Harnett County
420 McKinney Pkwy
LILLINGTON, NC 27546
Phone:
Fax:

SUBJECT: SFD2105-0020
SINGLE FAMILY DWELLING

Here are the results of all Inspections located at **145 BROWN RD:**

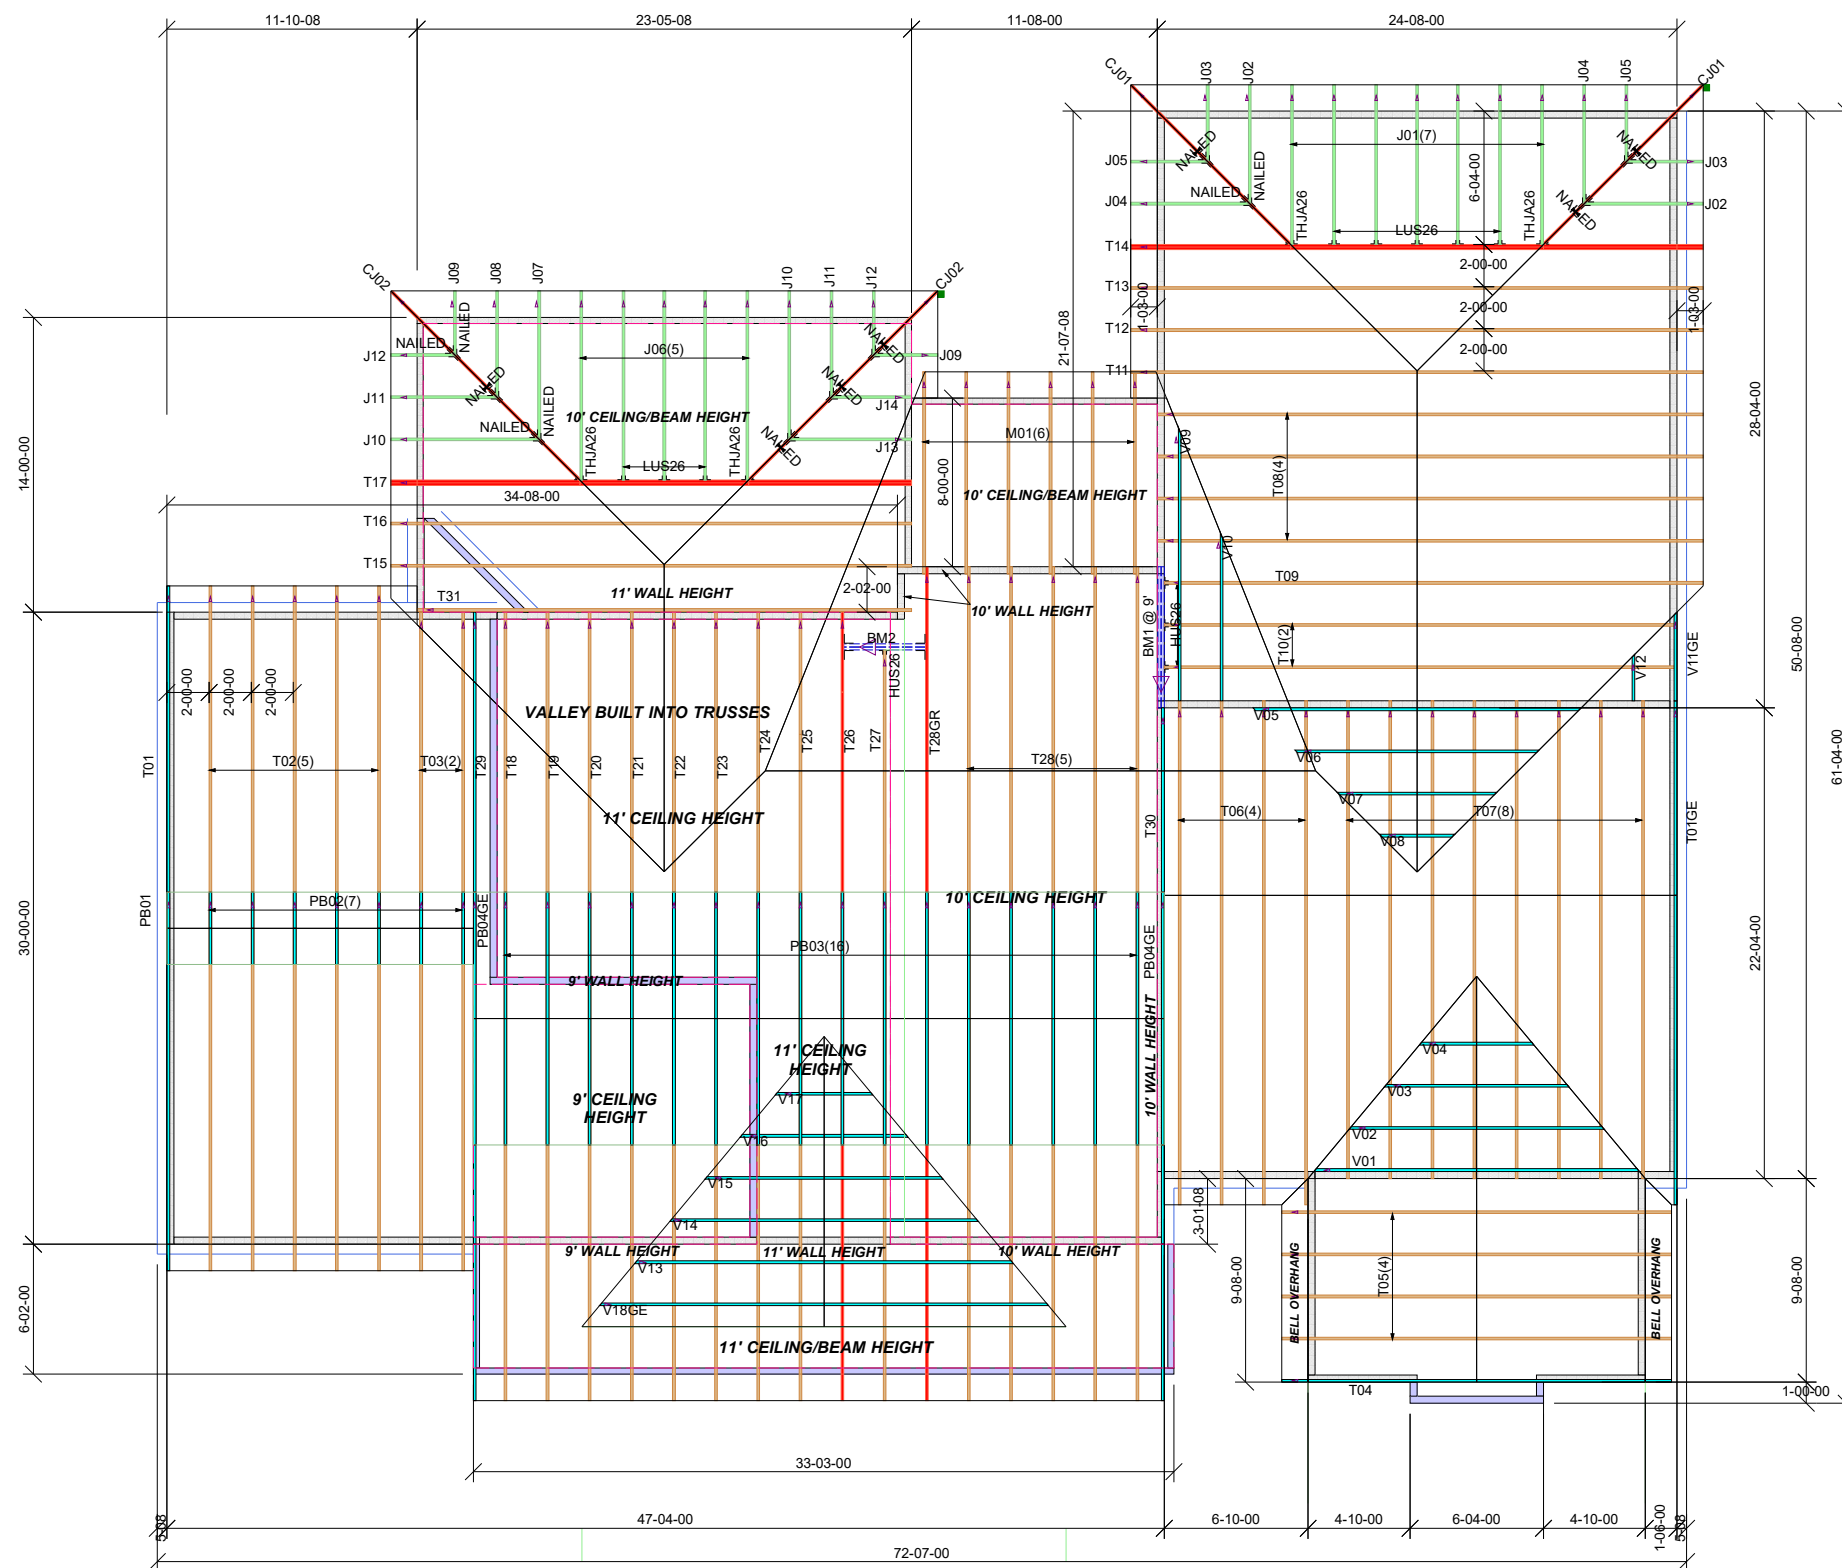
1.Strap each side of garage door per portal framing in code. 2.Missing 2x2x5/16" square washers on wing walls in garage per code and nuts and washers. 3.Missing all doors & windows. 4.Missing anchor bolt & nuts & washers @ window in garage.5.Strap each end of lvl beam in garage that supports roof truss. 6.Nail all 2 & 3 ply lvls per documents. 7.Missing hurricane strap on truss on right side of garage. 8. 3' head of water on drain line test. 9.Replace notched stud on back wall in master closet & master bedroom. 10.Missing nails in hurricane strap on 2ply truss in master closet. 11.Missing nut & washer on anchor bolt back left corner master bed. 12.Missing nails in roof truss hangers in master bed.13.Missing baffles. 14.Missing nut & washer @ dryer duct in laundry anchor bolt.15.Missing hurricane strap on laundry room wall.16.Anchor all interior load bearing walls per code.17.Fire caulk water line @ refrigerator top plate.18.anchor bolt missing each side back door, left of window in living room, back left bed closet, front bed & dining on garage wall. DO NOT INSULATE
